Our ref: NA/2020/115170/01-L01
Your ref: TR010059
Date: 29 October 2020

A1 IN NORTHUMBERLAND: MORPETH TO ELLINGHAM MORPETH TO ELLINGHAM RELEVANT REPRESENTATIONS (SEPTEMBER - OCTOBER)

We have reviewed the Development Consent Order (DCO) application, Environmental Statement (ES) and supporting documents and have a number of concerns regarding the proposed development and matters within our remit. We therefore make representations in relation to the following areas:

Drawing Number	HE551459	Originator	WSP	Volume	6.6	Project Ref. No.	70044137
Location	A2E	Type	RP	Role	LE	Number	2130
						Revision	P04

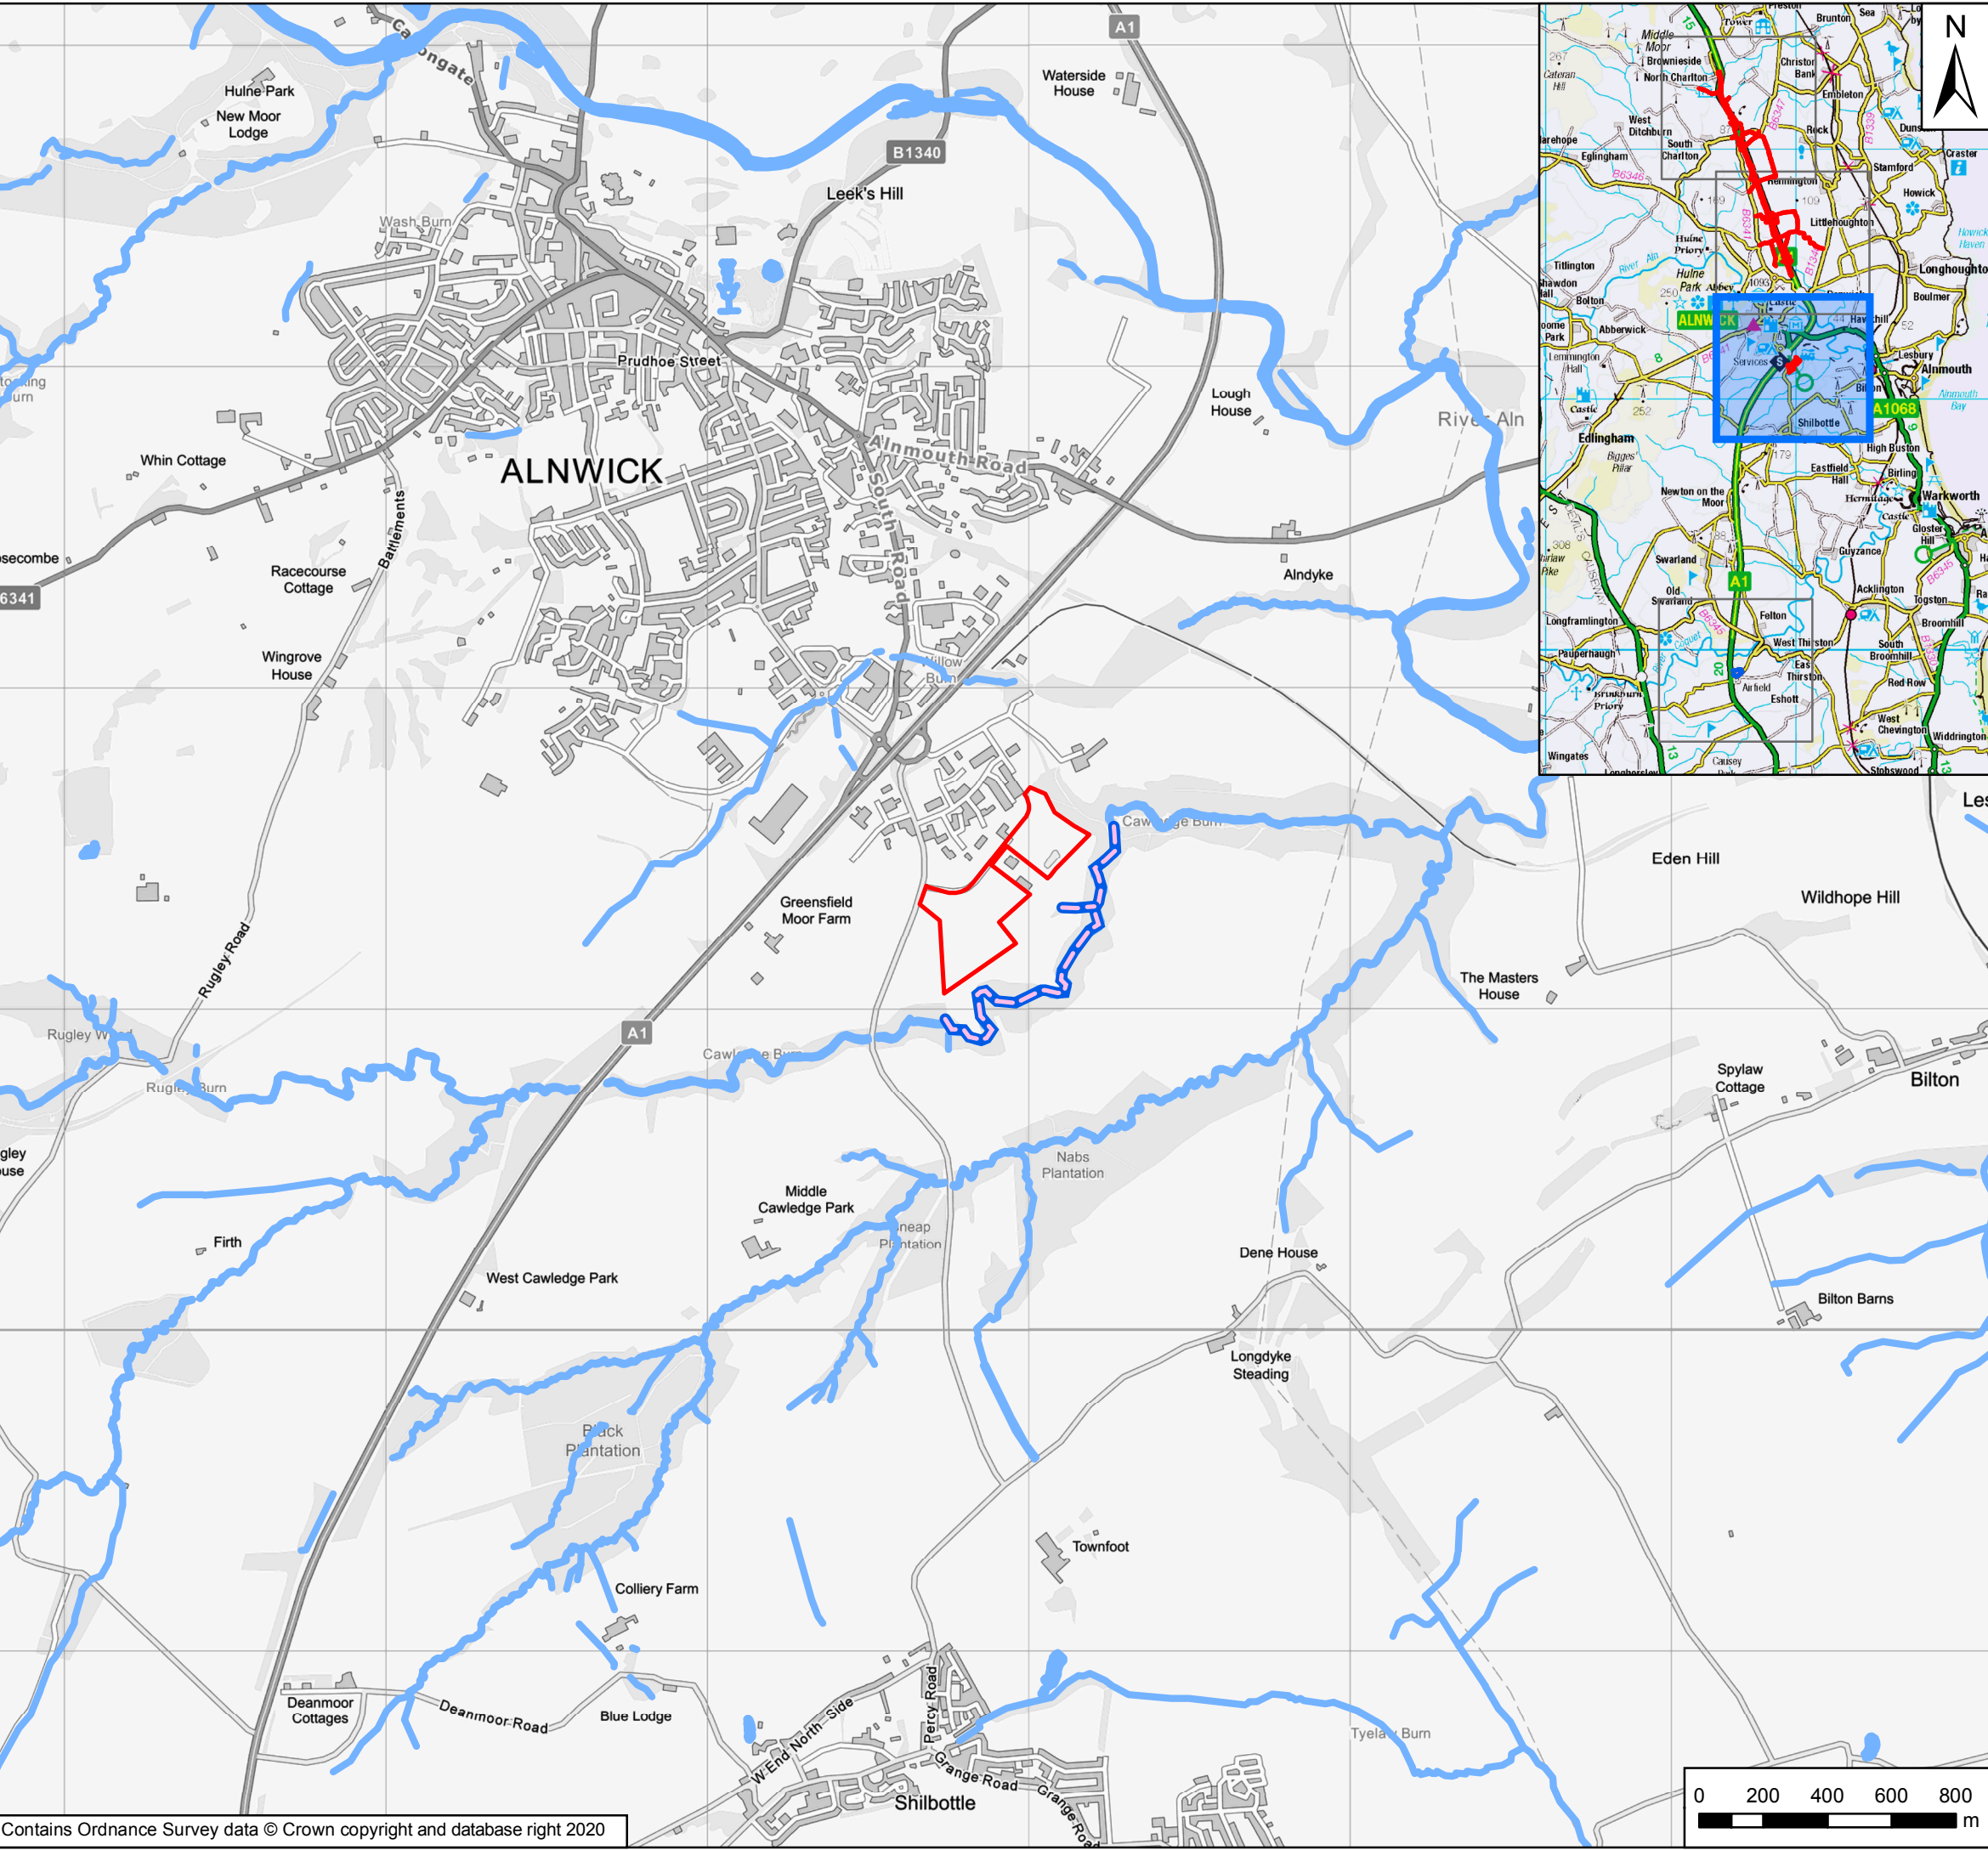
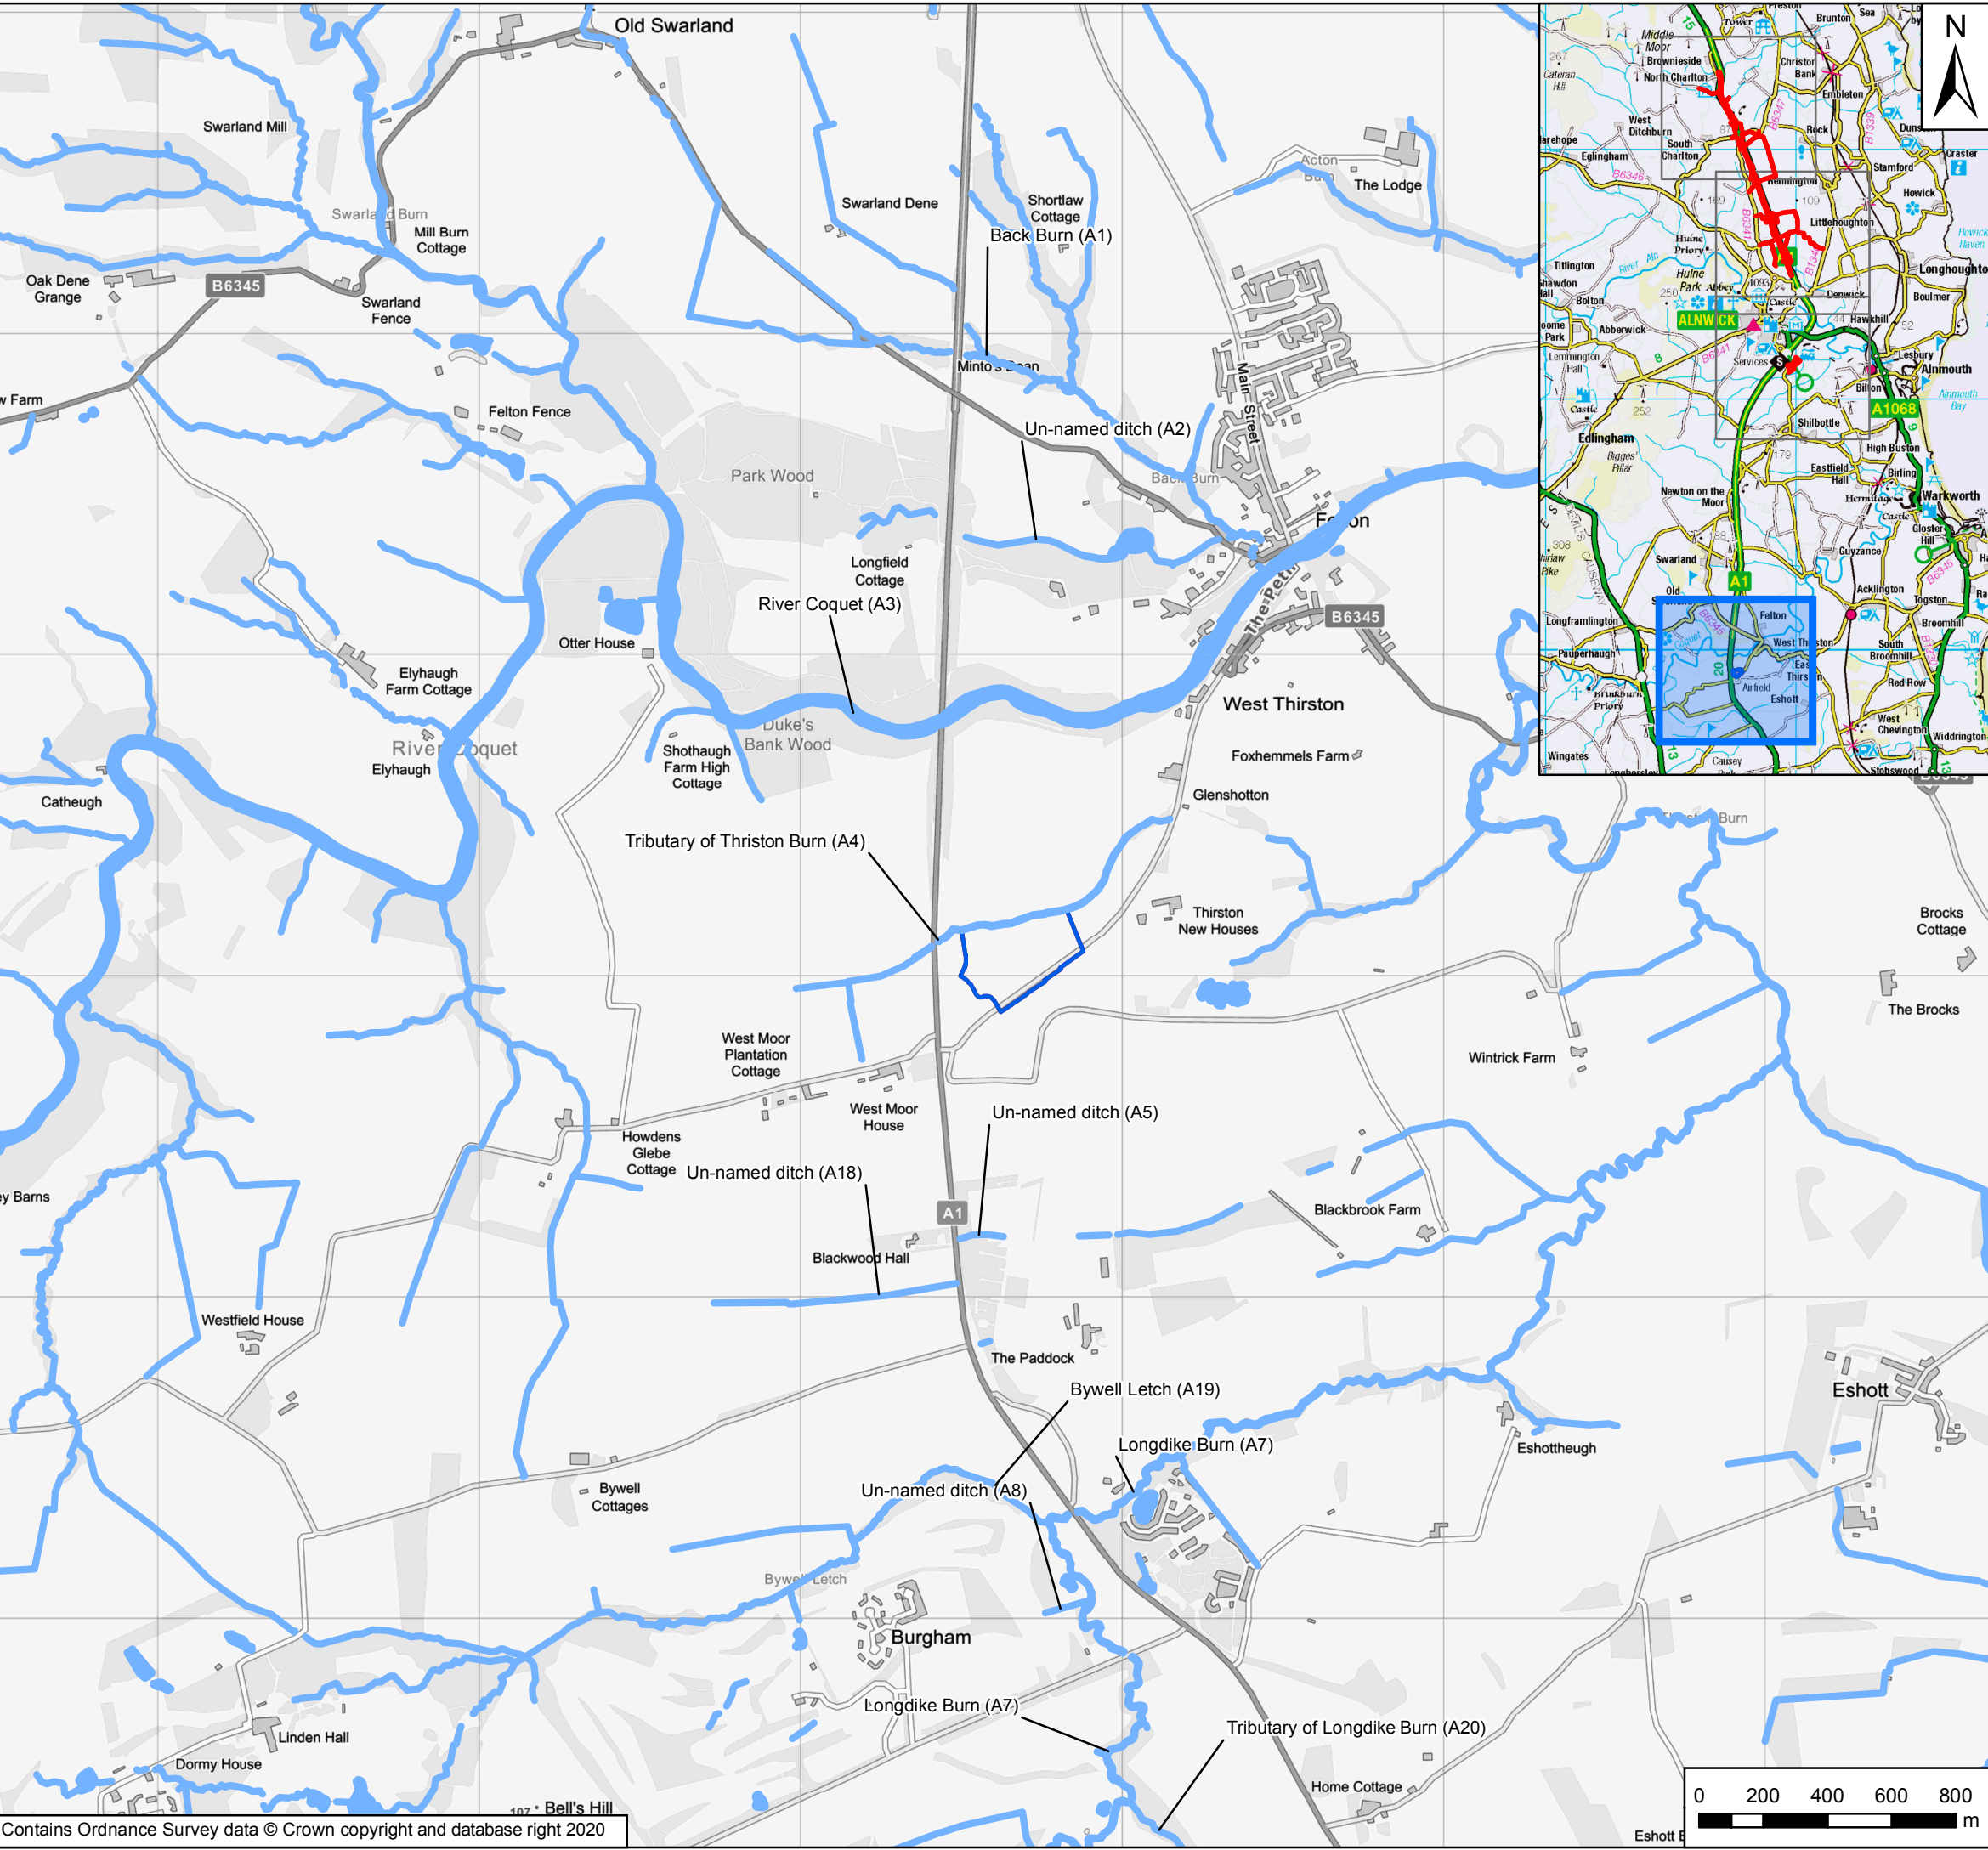
The lack of consideration for otter in Part B is unacceptable, given that they are a highly mobile species and are slowly naturally expanding their ranges. Therefore, we object to the proposed development due to inadequate assessment of otters. Our records show 24 records of otter within 5km of Part B. Given they have ranges of up to 32km, there is a high potential for otter to be as a minimum, transient in the local area. The scheme will become a permanent feature in the landscape and become a new major barrier to movement should otter colonise the area or expand current ranges. Therefore the operational phase of the scheme is likely to cause mortalities of otters due to the lack of wildlife friendly culverts or crossings. The potential for otter to be present in a forward looking manner is required, giving further consideration to risk of mortality in the operational phase.

The mitigation designs and the scheme drawings should be updated and take into consideration the impact of the development on otters. Given the known presence of otter in Part A, and potential in Part B, wildlife crossings should also include mammal fencing to ensure otters and other mammals, such as badger are directed towards wildlife friendly crossing points. We note that there is some badger fencing designed into the scheme, this needs serious consideration for other potential mammal crossing points.
